**From:** Gillett Macleod Partnership <gmpartnership@yahoo.co.uk>  
**Sent:** 16 February 2023 16:47  
**To:** Richard Phillips  
**Cc:** Frank Leahy; j.nash@daylightandsunlight.co.uk  
**Subject:** Re: FLC Car Sales, Falling Lane, Yiewsley - Ref: 692/APP/2022/1741  
**Attachments:** Proposed site plan.pdf; Proposed north north east and north west west elevations.pdf; Proposed first floor plan.pdf; Proposed ground floor.pdf; 15 February 2023 - Daylight and Sunlight Report.pdf; Appendix B.pdf; Proposed north east east and north north west elevations.pdf; Proposed south elevation.pdf; Proposed roof plan.pdf; Proposed third floor plan.pdf; Proposed second floor plan.pdf

I have compared the drawings submitted to support the live application, no: 692/APP/2021/4071 with the corresponding drawings in application No 692/APP/2017/749. Below are the comments on changes.

SOUTH ELEVATION
(HIGH STREET AND FALLING LANE ELEVATION)

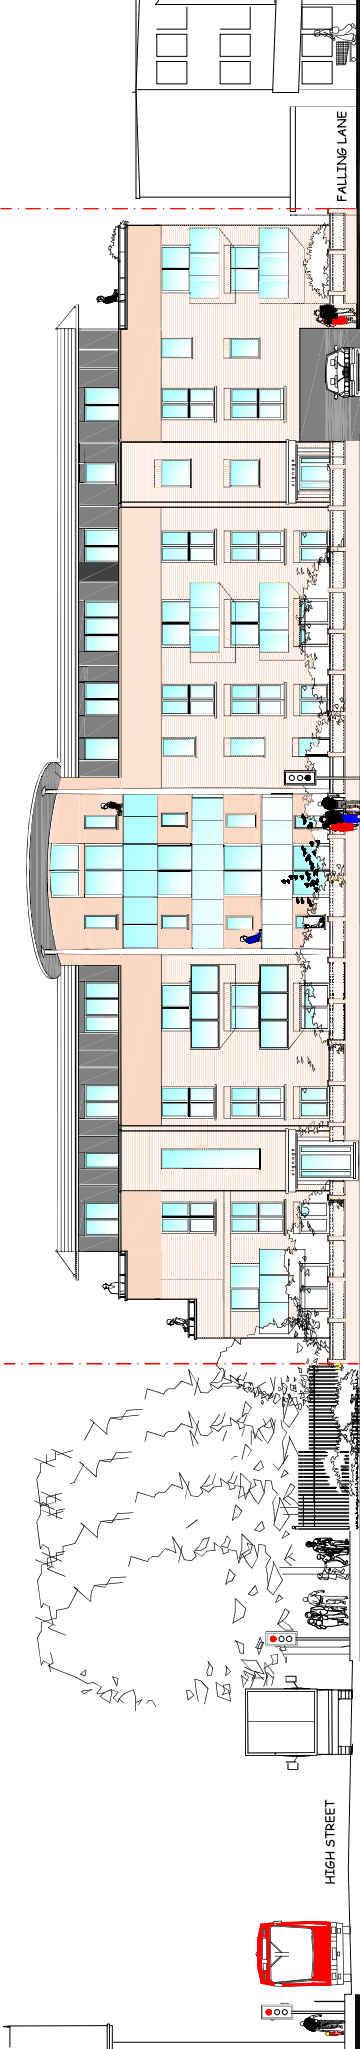
1. The original 2017 drawings showed balconies integrated into the architecture along the Falling Road profile these are replaced with glass balconies on the current proposals. I assume the graphic indicate glass although, a key of material is not shown. The original proposals provided a positive architectural profile to the building and avoided views of clutter that can be stored on balconies. This value engineered approach has reduced the design quality of the building and should be reverted to the original design. See images below as an example.

We have had a light report prepared which is attached herewith to answer the urban designers comment No 1 to show that there will be adequate natural light to the rooms immediately below the proposed balconies.

There were a couple of exceptions which required the slight enlargement of the windows. We have amended the drawings accordingly.

Please find attached revised drawing Nos 15/2936/102B, 104B, 105B, 106C, 107C, 108C 109B, 110B and 111B which have been amended accordingly.

Drg. No.15/2936/105A		REVISION
Scale	1:100	A
Date	21/01/22	
Drawn by	AK	
		(C) drawer

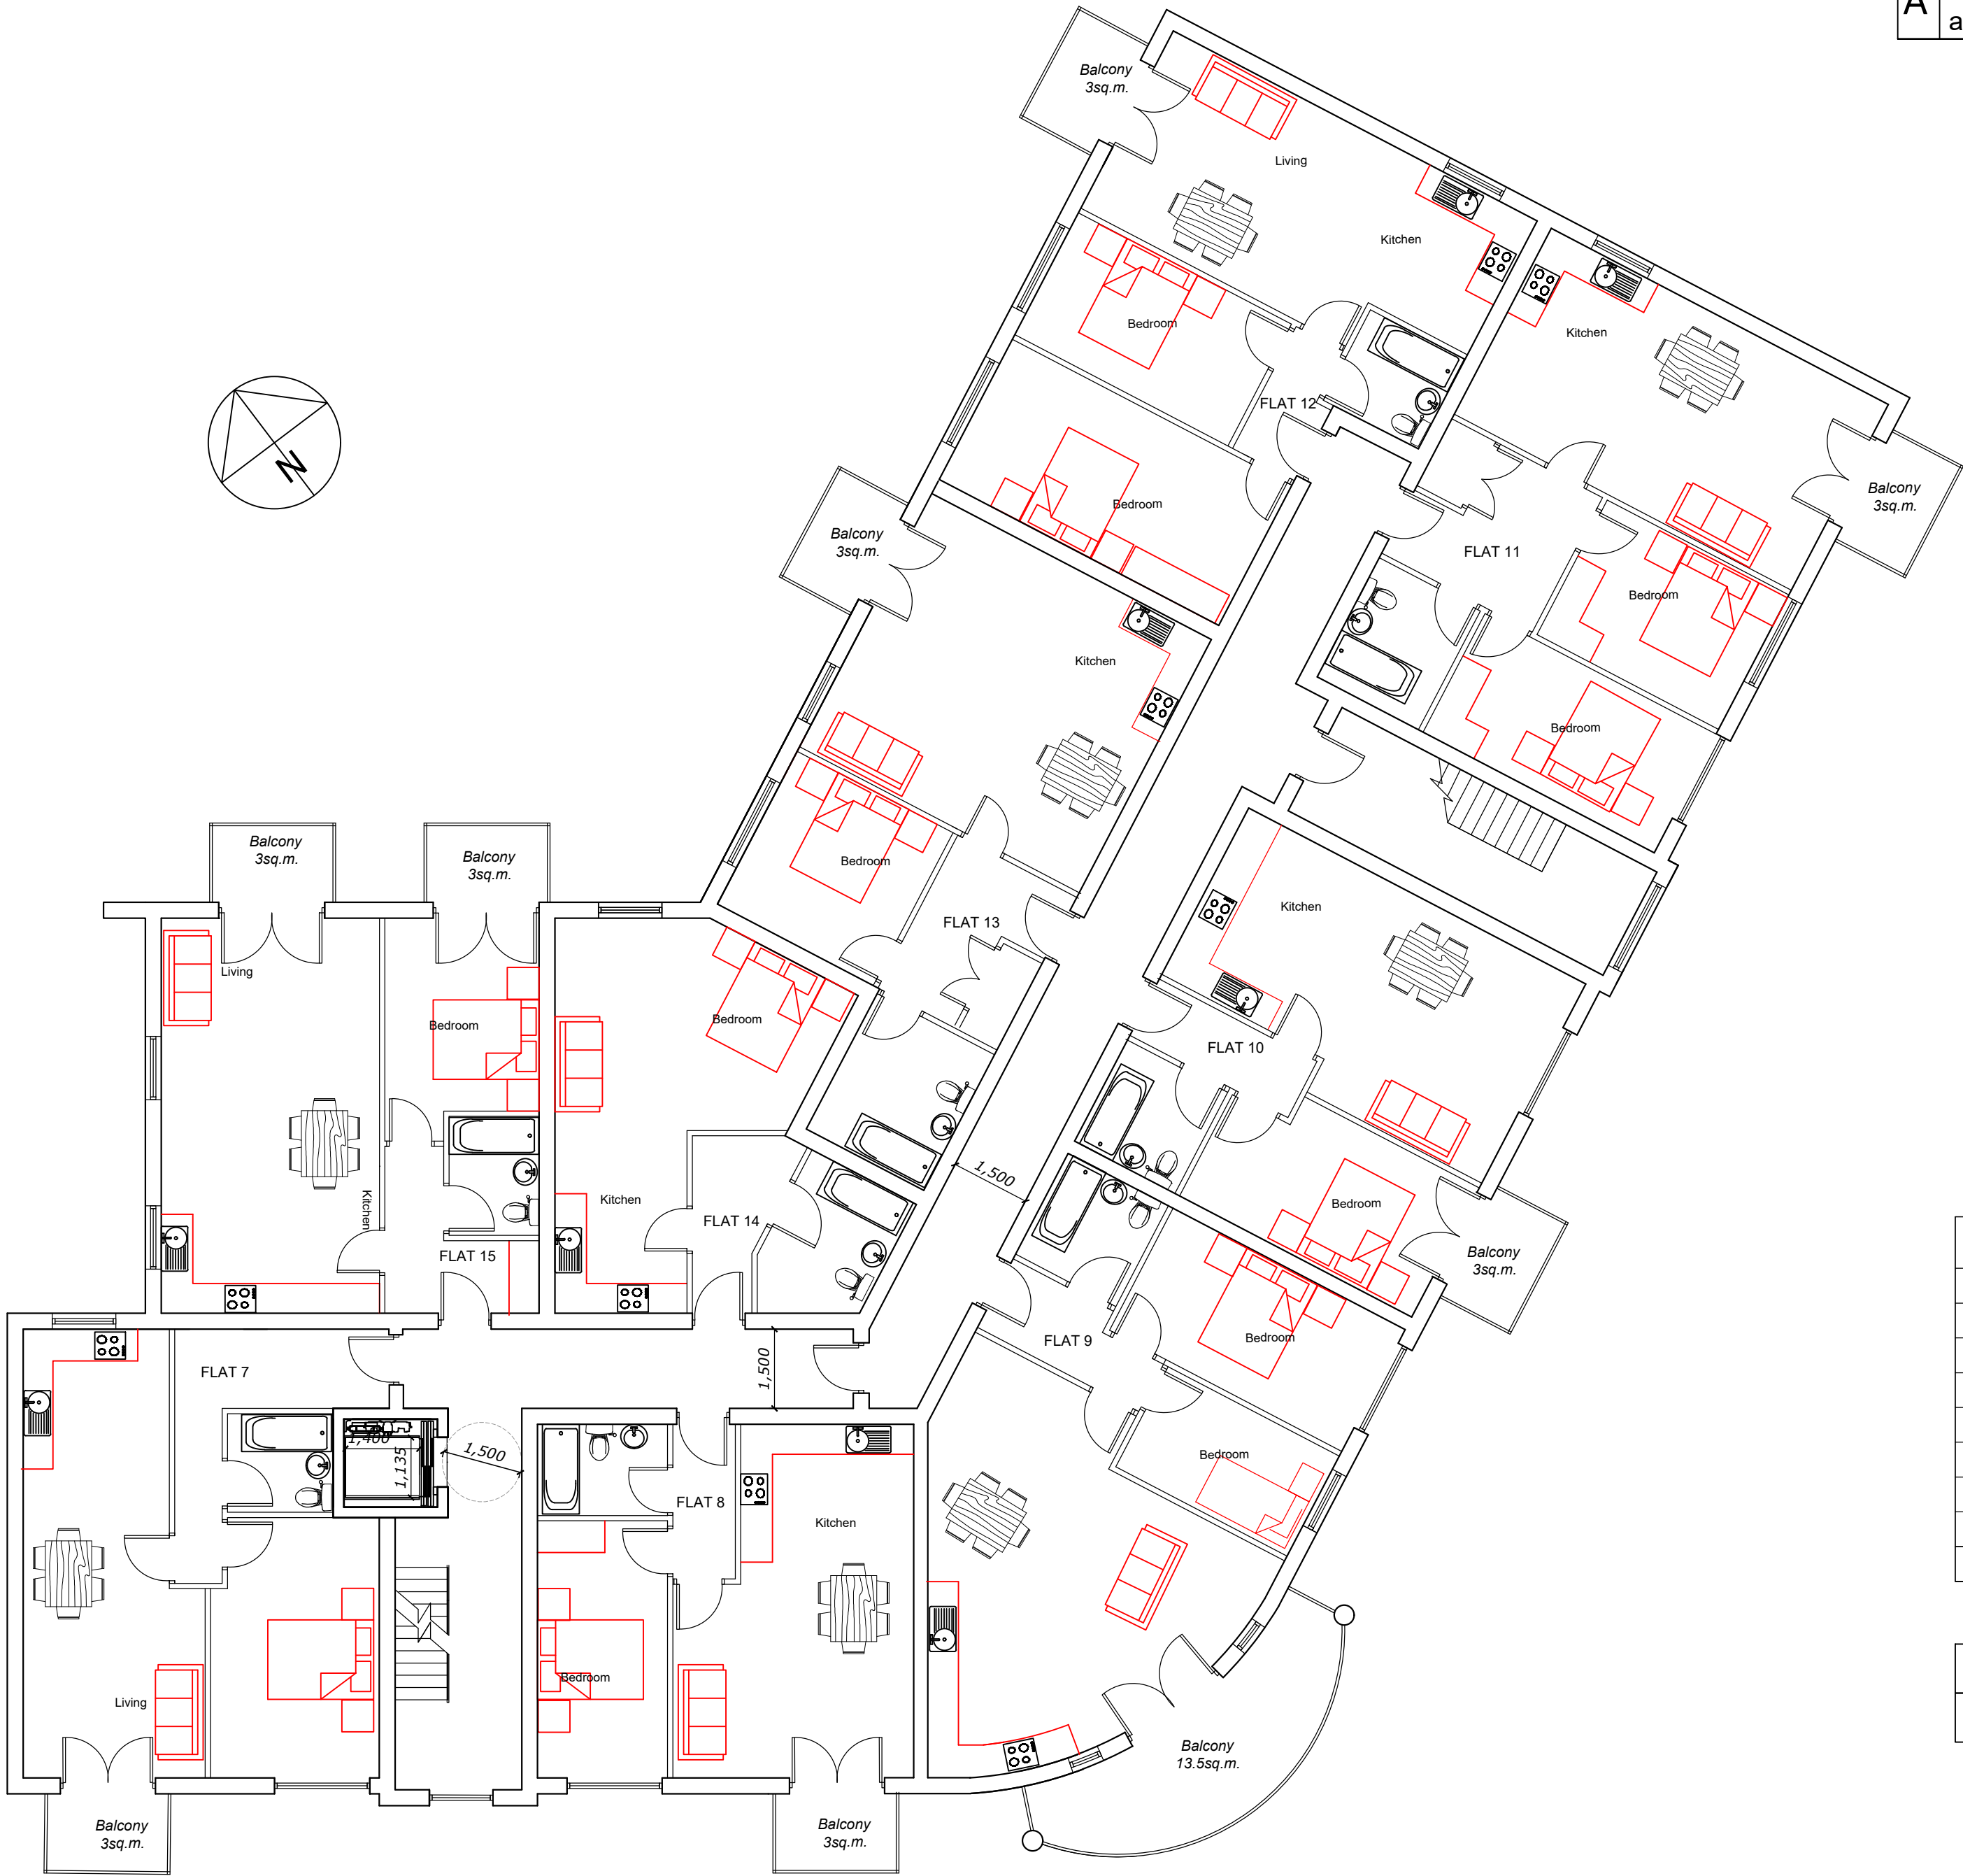
As a result of reducing the size of the communal staircases, some of the adjoining units have been made marginally larger, but the floor areas in the accommodation schedules have not changed.

Having measured the units from your plans, I also note that a number of the units do not satisfy minimum floor space standards, eg. Flats 2, 3, 8, 11, 12, 17, 20, 21, 25 and 30, although the schedules have not been revised and would suggest they do. The short falls are not great but any S73 application would need to be fully compliant and this also needs to include minimum bedroom sizes and widths and provision of storage space as required by Policy D6 of the London Plan (2021) and a number of units do not satisfy these bedroom and storage minimum requirements. The changes need to be made to satisfy Policy D6 whilst minimising any deviation from the approved plans if the need to submit a S73 for the outline is to be avoided.

I also note that many of the proposed balconies are undersized as to accord with Policy D6, they need to have a minimum size of 5sq.m and depth of 1.5m.

Further to your email of 13th June 2022 and our subsequent team meeting, we have amended our plans inline with your email and adjusted the room sizes, balcony sizes etc. We have also adjusted the site layout plan so the basement car parking matches the outline plan exactly. I attach copies of our revised drawings No.'s:
